Permit Number: 030034

This is to certify that GCA/Motel 6/Glen Duvall
has permission to Renovations to 58 Bathroom Motel
AT 1 Riverside St 266 A001001

Proposed Use: Motel	Proposed Project Description: Renovations to 58 Bathrooms in Motel
-------------------------------	--

**NEW BATHROOM # 1273
PORTLAND, ME.**

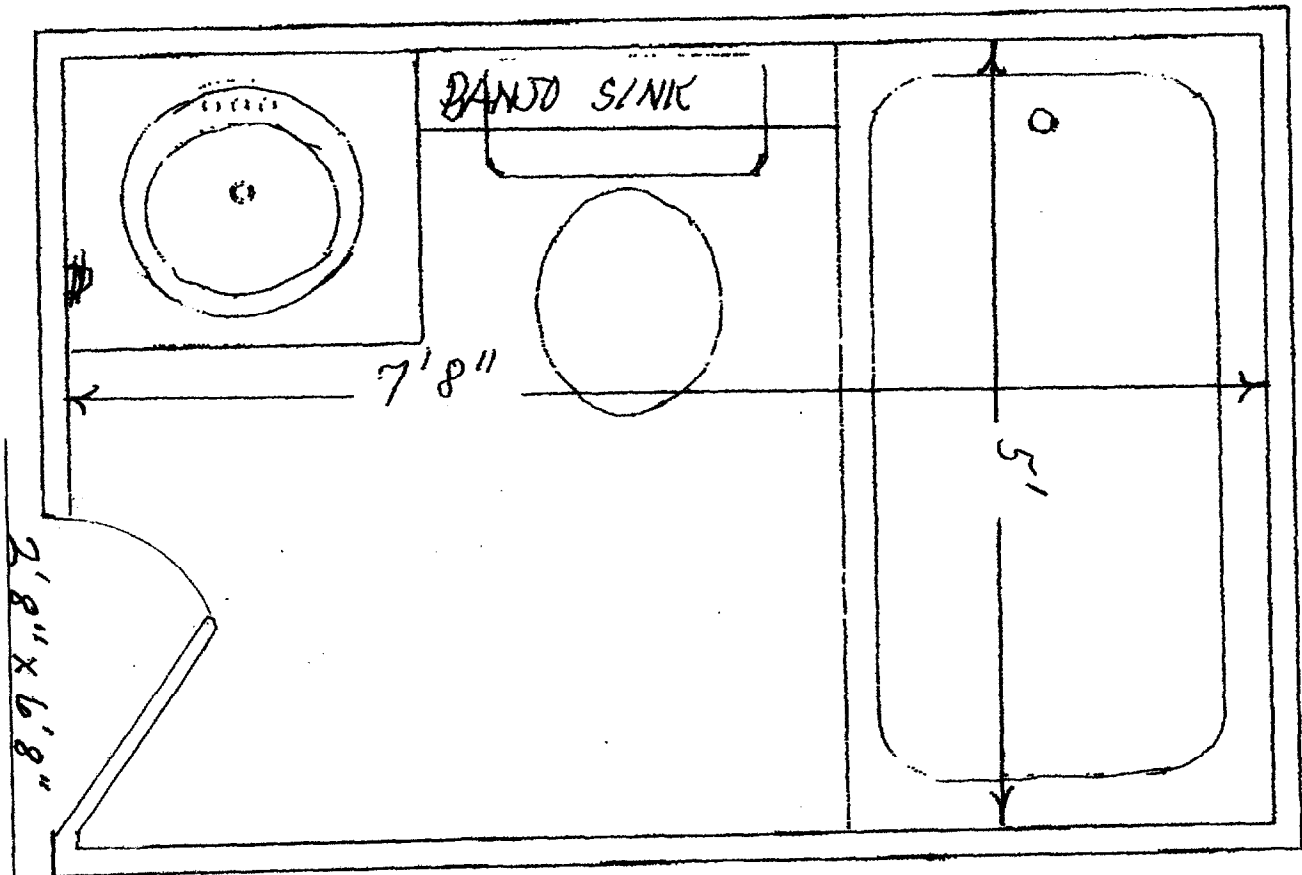
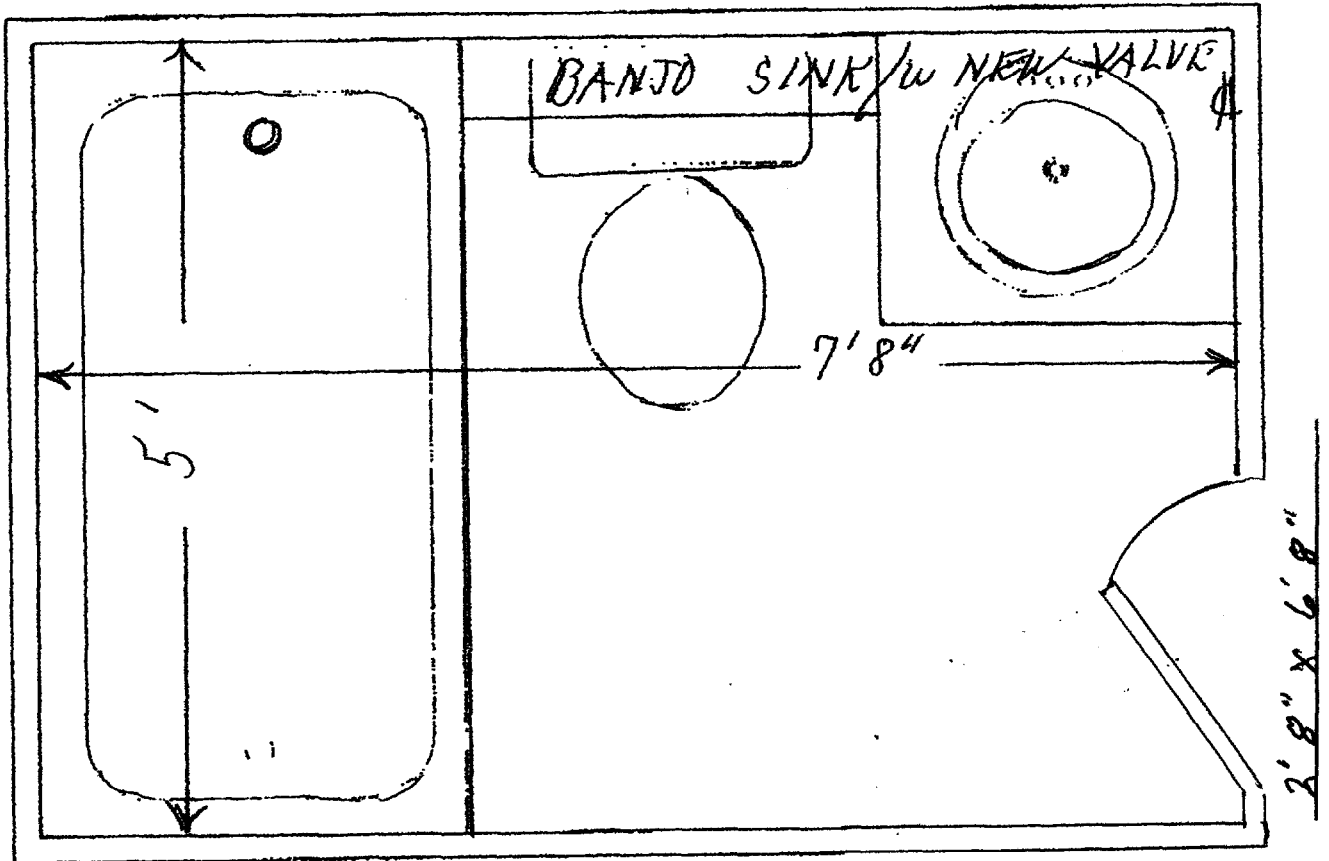
1) Bathroom Doors must be 32" in width, Confirmed with BOCA this date Mr. Duvall from Motel 6 agreed to conform.
